Your Ref: OWPC19374
Our Ref: EP/96/18/DOC 26-06-2018
Please ask for:
Mrs A Gardner

23rd July 2018

Application for approval of details reserved by condition imposed under planning permission EP/59/17/PL (Appeal no. APP/C3810/W/17/3183667) relating to condition No. 9 (Surface Water drainage works) & 10 (Sustainable drainage scheme)
Tudor Lodge 125A Sea Road East Preston

L2340-C-52-750 – Drainage for Planning

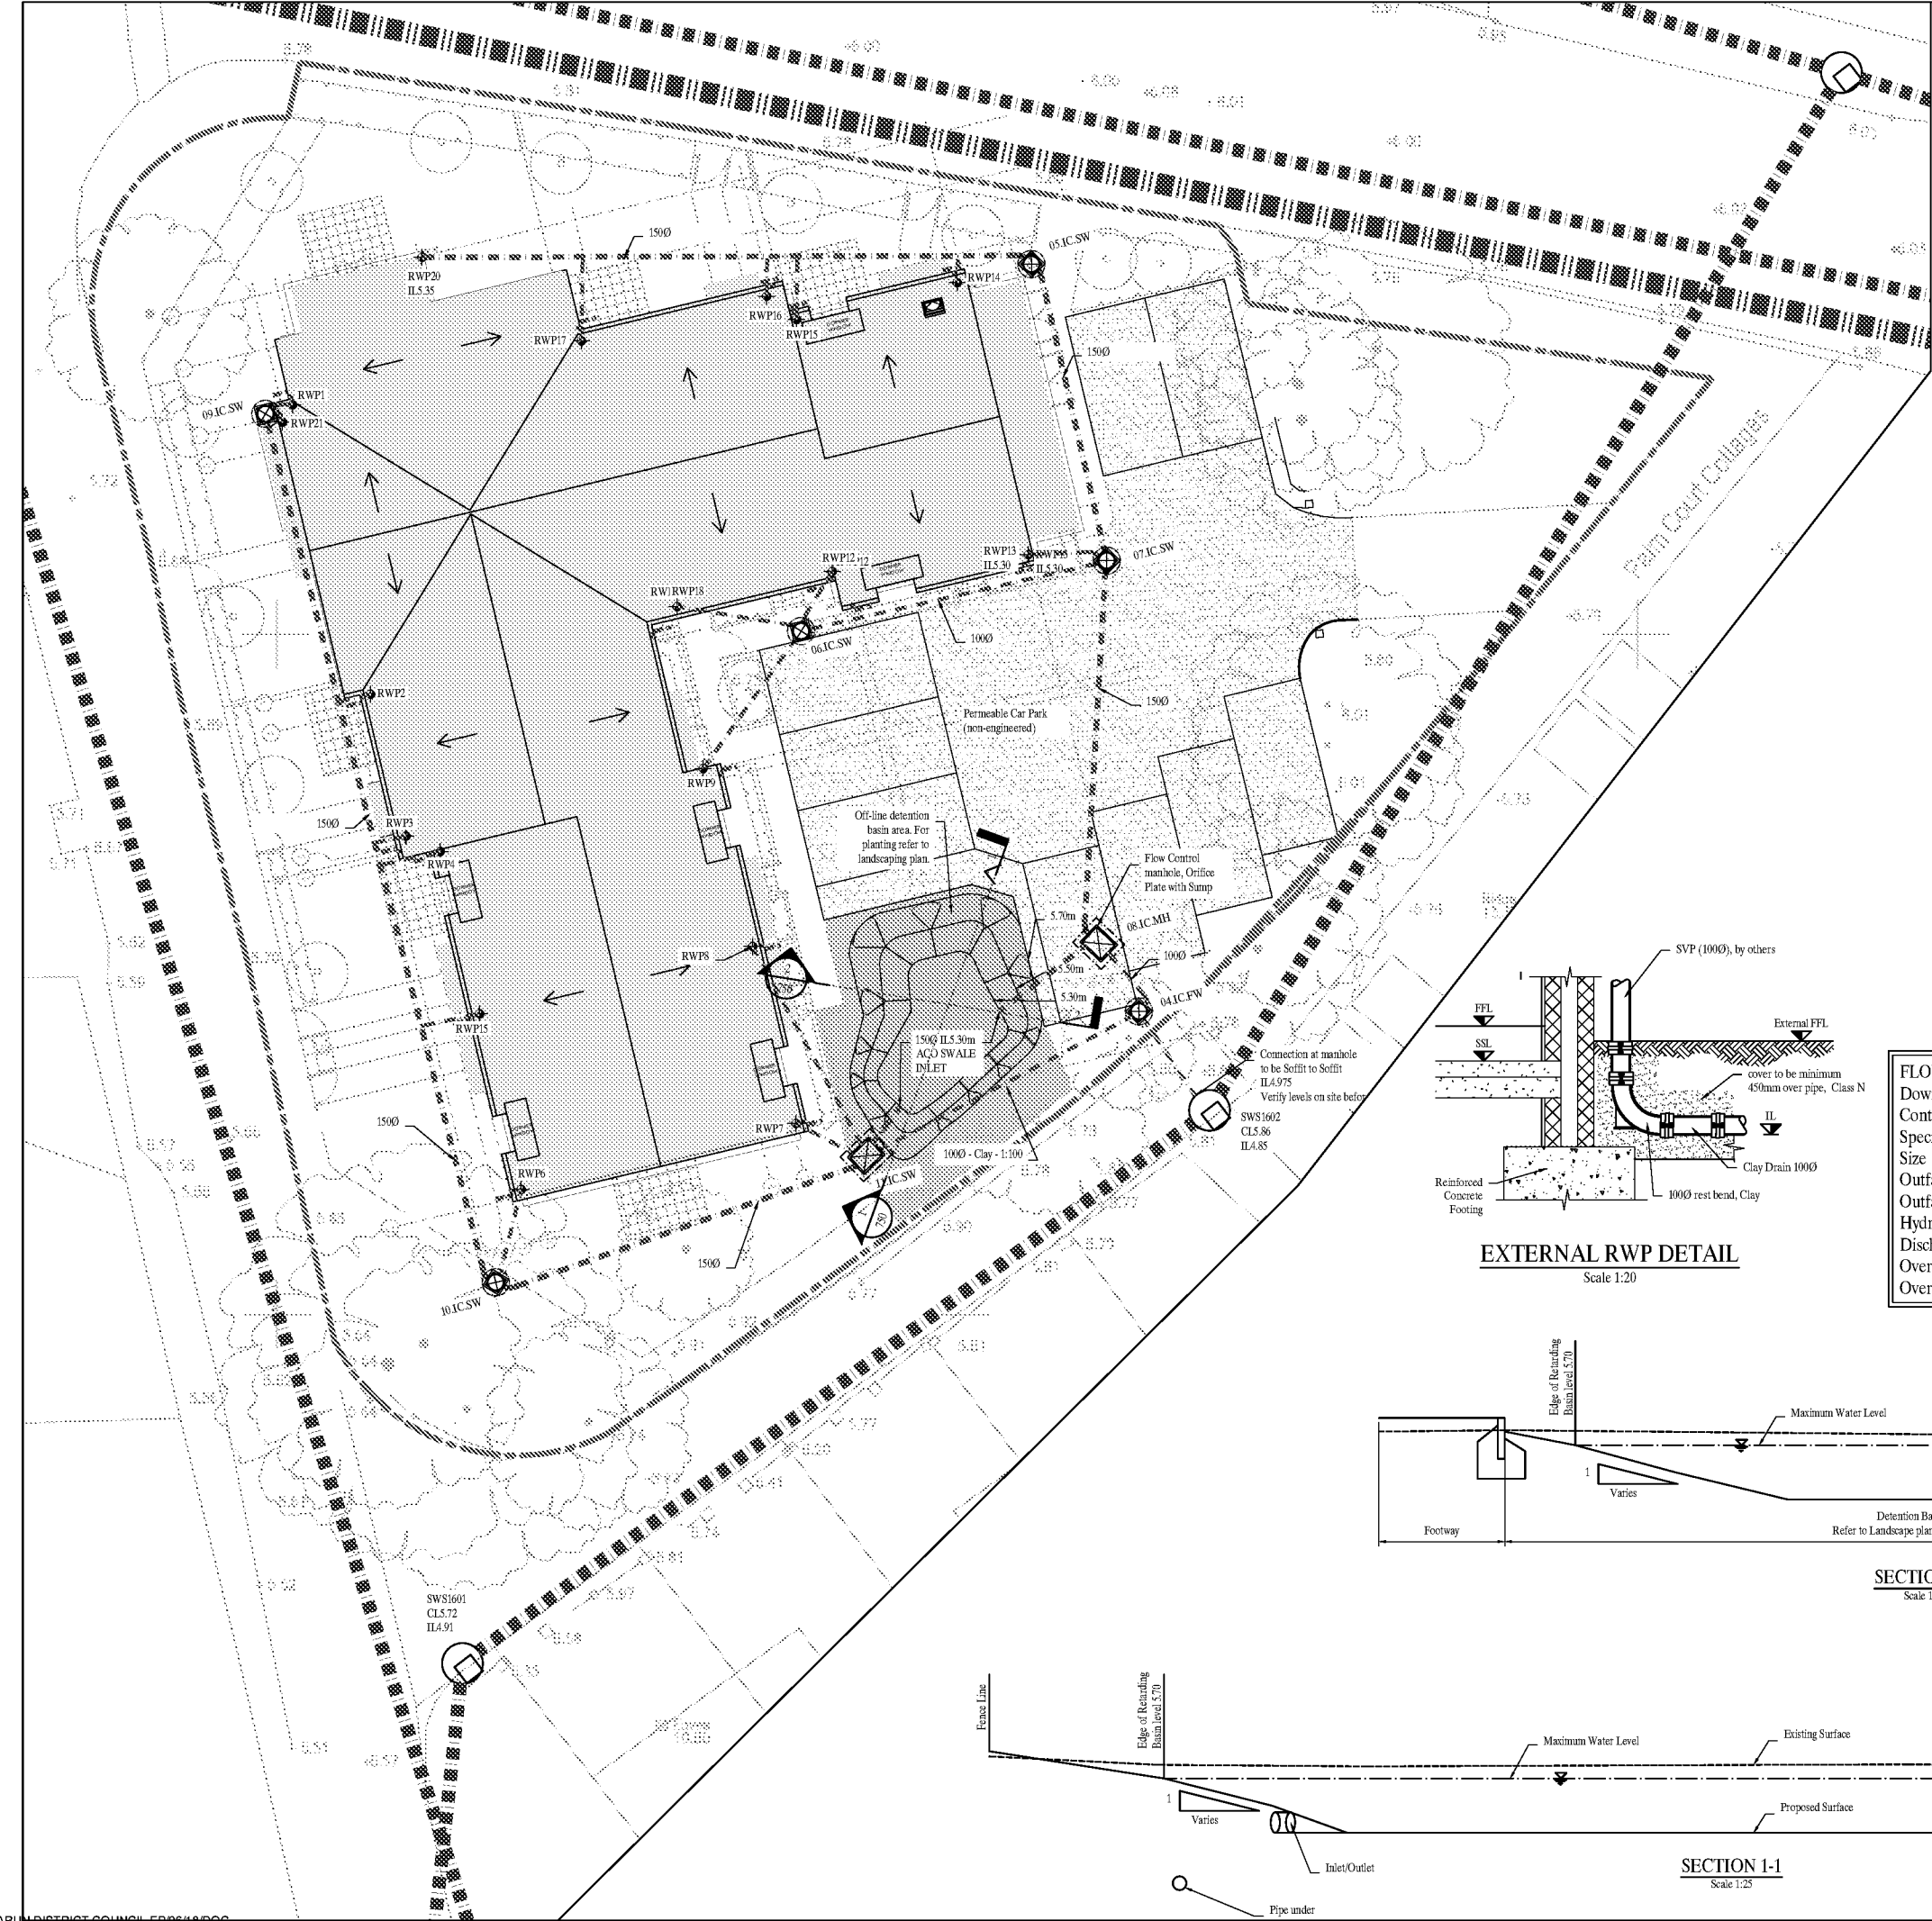
The new surface water drainage system will, according to the diagram at Appendix D of the construction engineer's technical note, connect to the existing sewer under Palm Court via an inspection chamber adjacent to the eastern side of the proposed detention basin. This new on-site inspection chamber will be the single point of connection to the existing off-site sewerage system via a chamber outside 6 Palm Court Cottages. The method of connection is unspecified. Surely this should be specified to ensure that it meets specified regulations.

- The existing sewer under Palm Court is capable of taking the increased flow from the new development;*
- The Estate's residents and land are protected from a less than suitable sewer connection; and*
- That the sub-surface soil and surface of Palm Court are correctly reinstated.*
